From: [Mark Fletcher](#)
To: [Sunnica Energy Farm](#); [Catherine Judkins](#)
Subject: Comments from the Isleham Society
Date: 13 September 2023 18:33:26

Isleham Society Objections to the Sunnica proposal

Drawing Title  
**FIGURE 10-14C  
 LANDSCAPE MASTERPLAN  
 SUNNICA EAST SITE B**

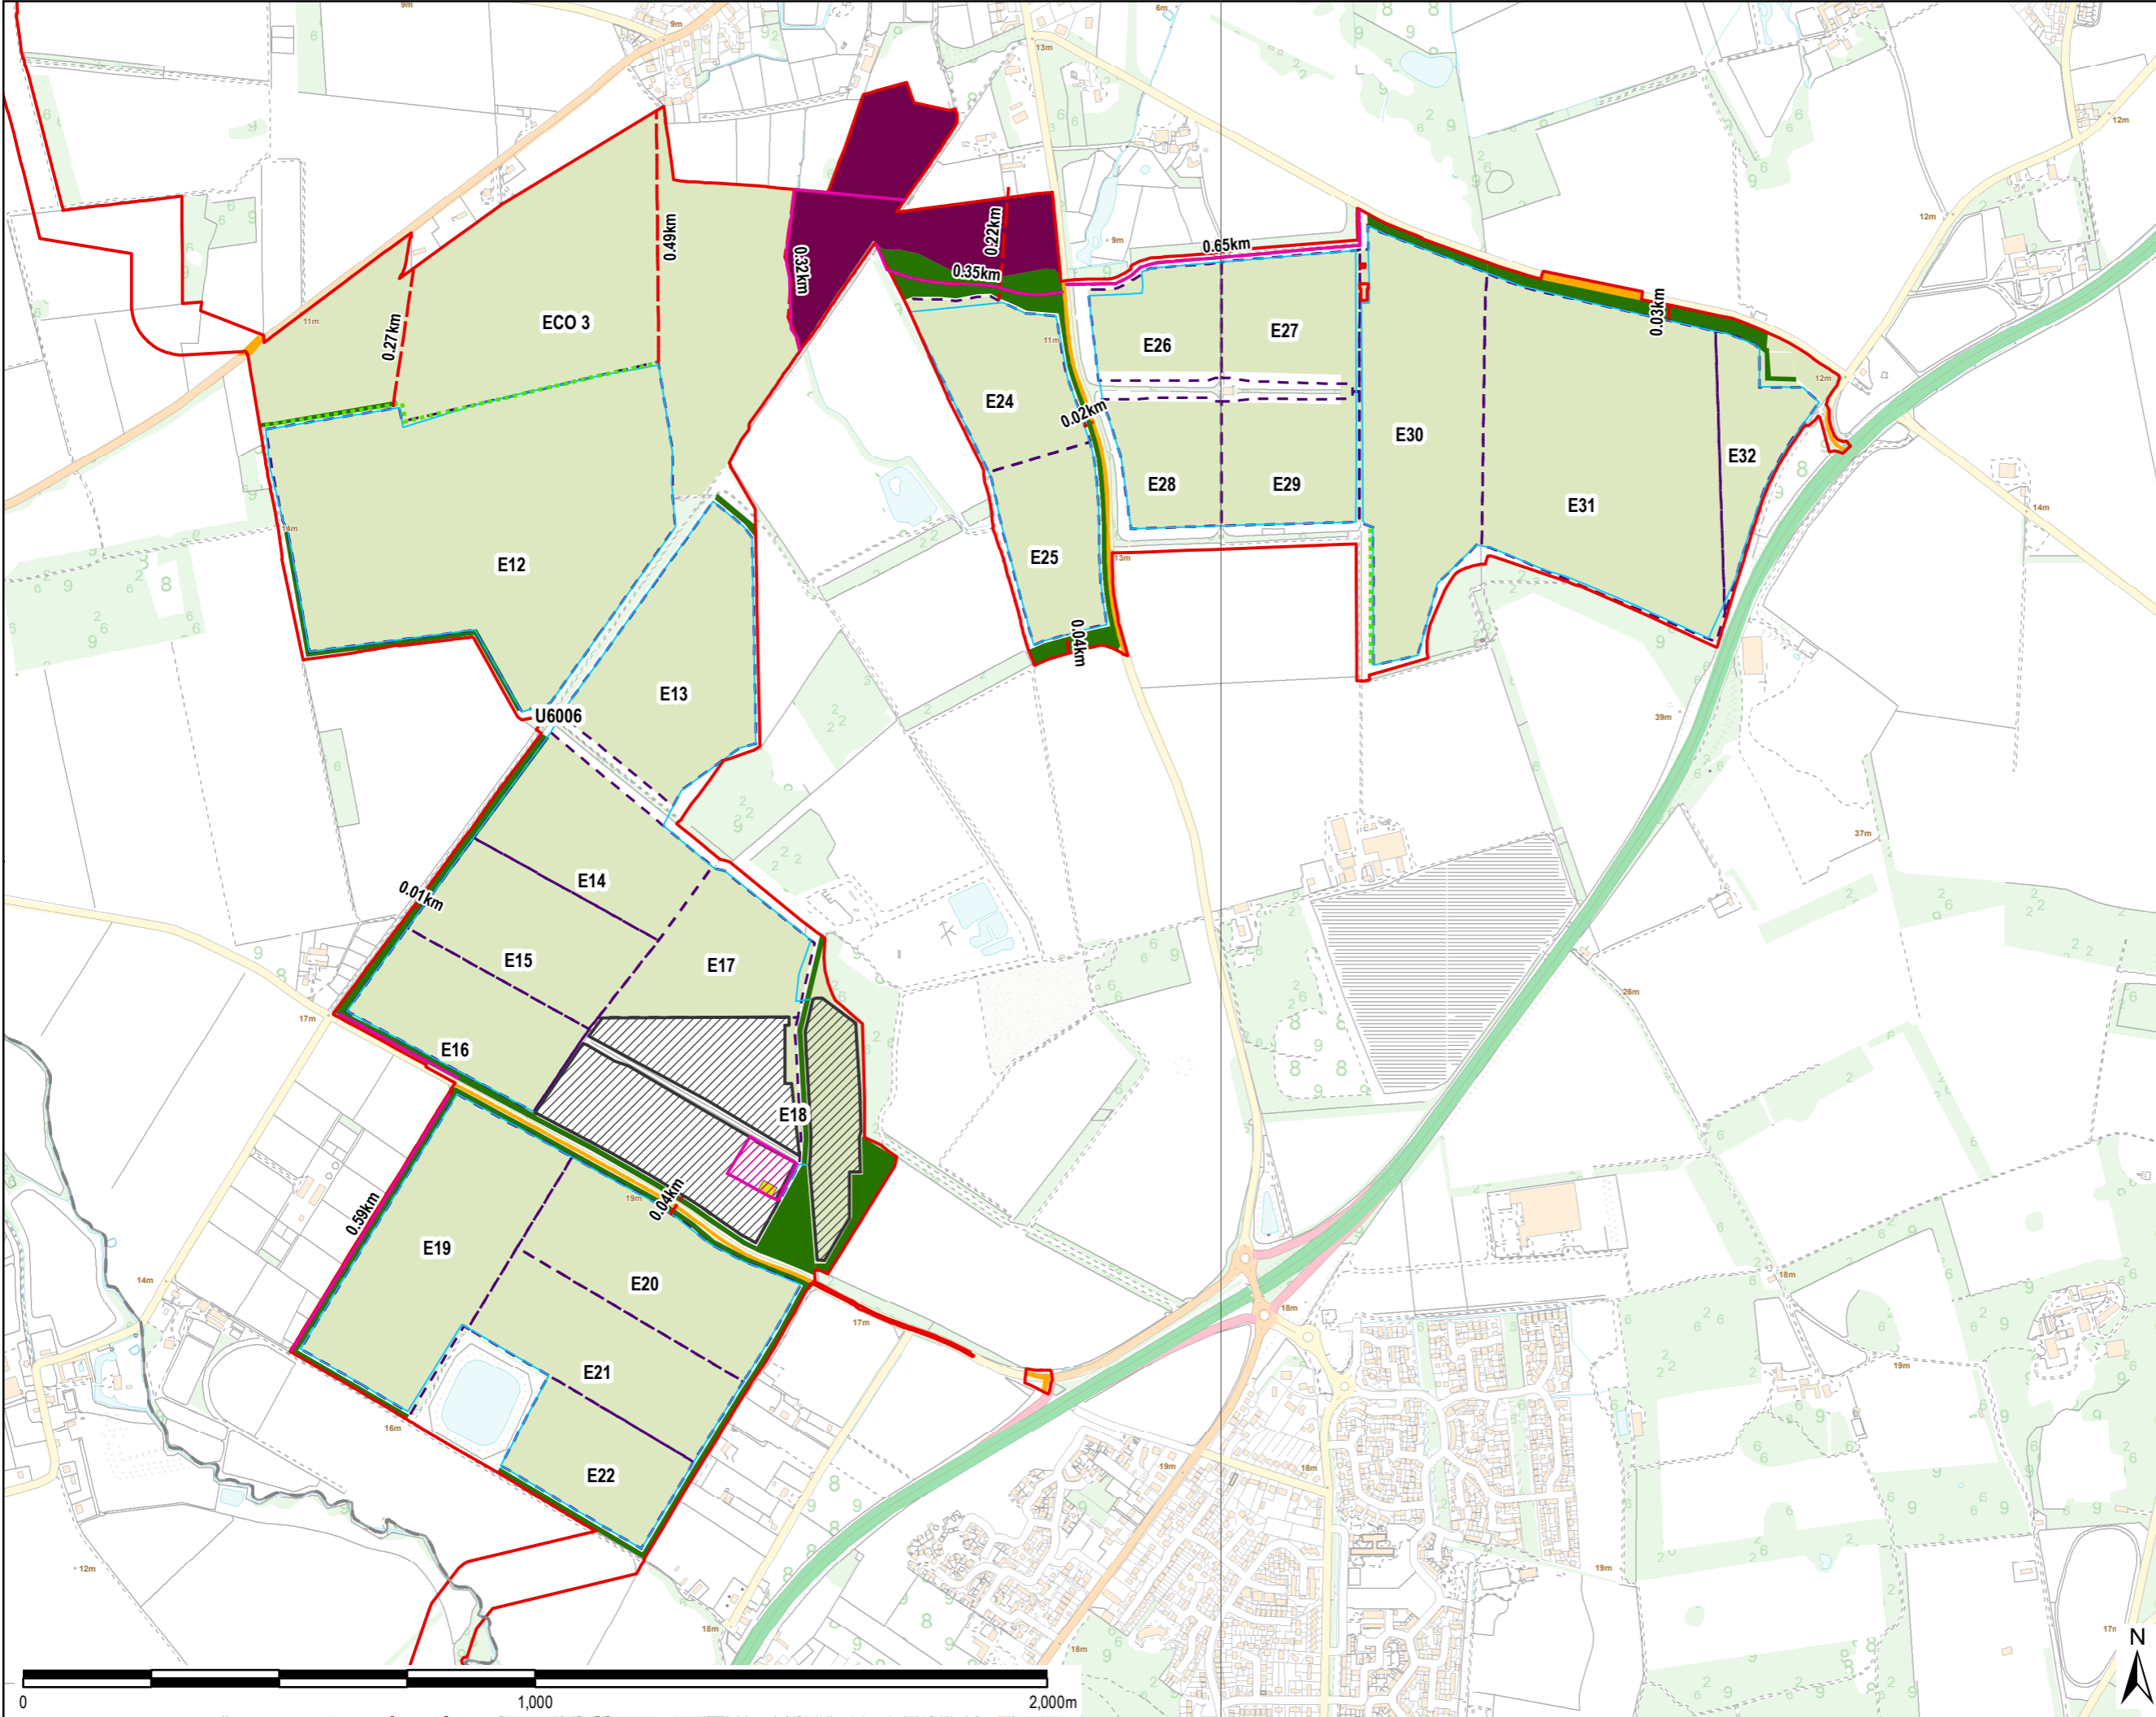
Sunnica plan to put a large area of woodland at the corner of Sheldricks Rd and Beck Rd. This woodland would follow the line of the field in the direction of East Fen Rd, where there would be another large block of woodland whole site will be fenced in. This is to be done to try and hide the ugliness of the scheme, but in doing so will sever the far-reaching view. In addition, it would alter the Fen Edge landscape which we value so much, - defined by open fields, with sparse vegetation. If we are to retain our identity as a Fen Edge village, we need to preserve the landscape that defines us as such. Fencing, trees and hedgerows in a place that hasn't had hedgerows etc before changes the characteristic of the area. Instead of Fen Edge, it would become an artificial landscape of no defined character. We are proud to be a part of the Fen Edge trail initiative linking Isleham to other Fenland villages along the 5m contour and retaining this landscape is an important essential.
